REQUEST	Current Zoning: I-1 (light industrial) Proposed Zoning: I-1 TS-O, (light industrial, transit supportive overlay, optional) with 5-year vested rights
LOCATION	Approximately 4.39 acres located on the north side of West Tremont Avenue between South Tryon Street and Toomey Avenue. (Council District 3 - Mayfield)
SUMMARY OF PETITION	The petition proposes to allow the development of 74 residential townhomes for a density of 17 dwelling units per acre on a vacant lot just outside of South End and 0.60 miles from the East/West Boulevard Station.
PROPERTY OWNER PETITIONER AGENT/REPRESENTATIVE	Various Carolina Capital Investment Partners Jeff Brown & Keith MacVean, Moore & Van Allen, PLLC
COMMUNITY MEETING	Meeting is required and has been held. Report available online. Number of people attending the Community Meeting: 6

PLANNING STAFF REVIEW

SHEET NO.: RZ-100

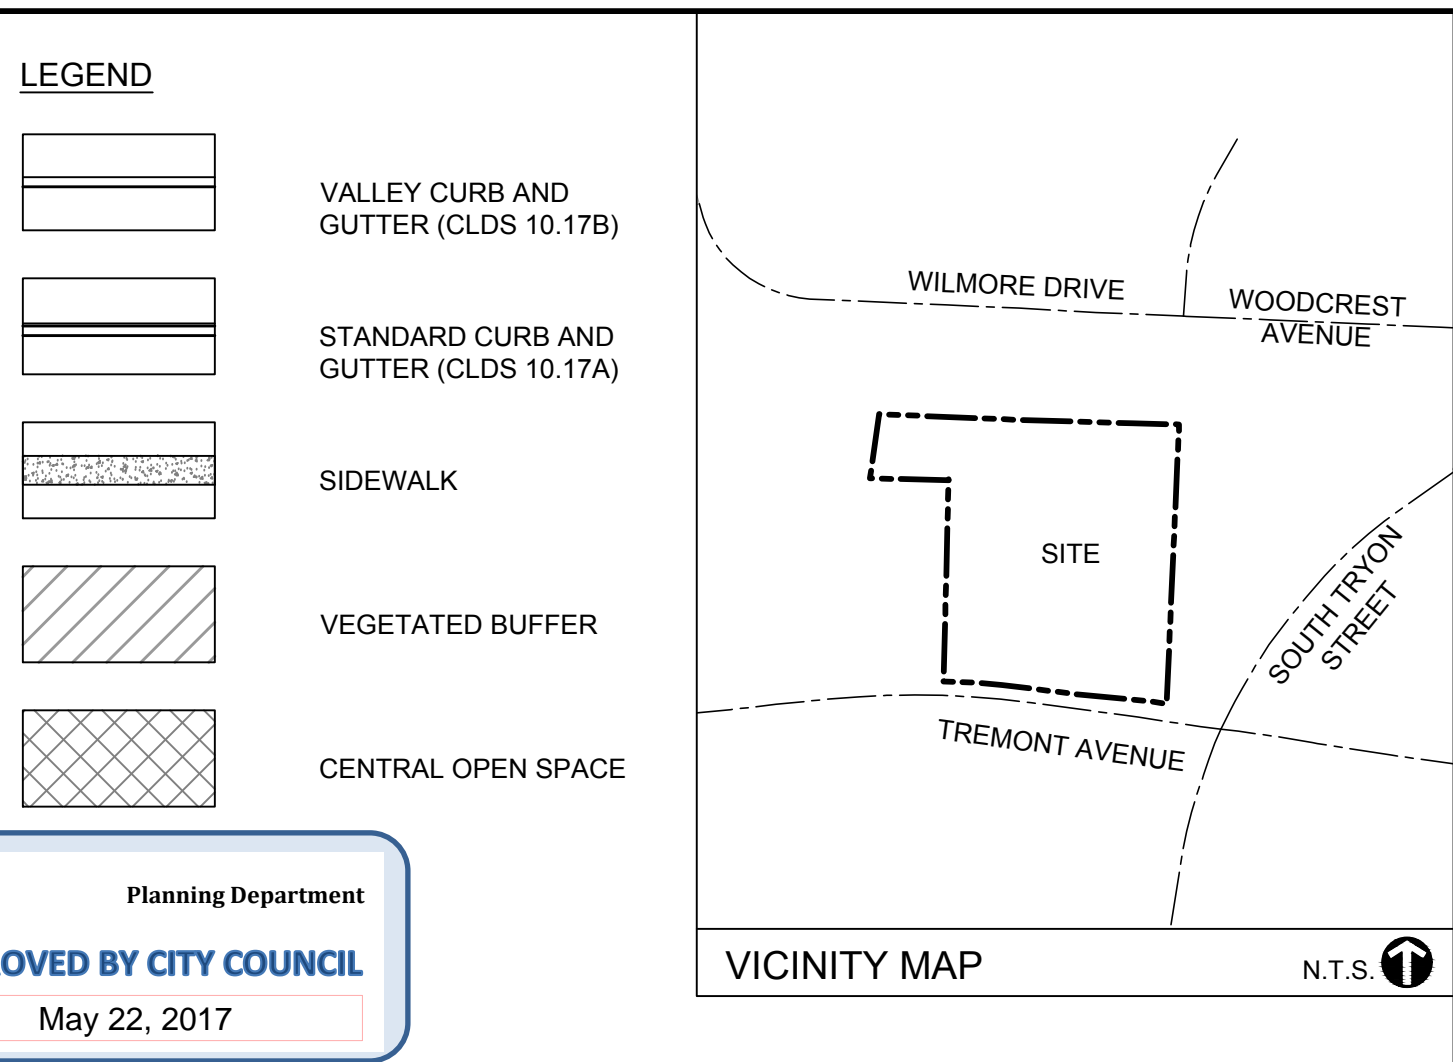
1. Clarify compliance with the ordinance requirements in Note "8B".

2. The petitioner should revise the site plan by relocating the proposed curb 27.50 feet from the existing centerline of road. This will comply with the area plan recommendation in addition to the future bike lane.
 3. The petitioner should revise the site plan and the transportation notes to depict and state that the petitioner agrees to allow future cross access to be preserved for such time that redevelopment occurs. This should include depicting stubs and access easements on the site plan.
-
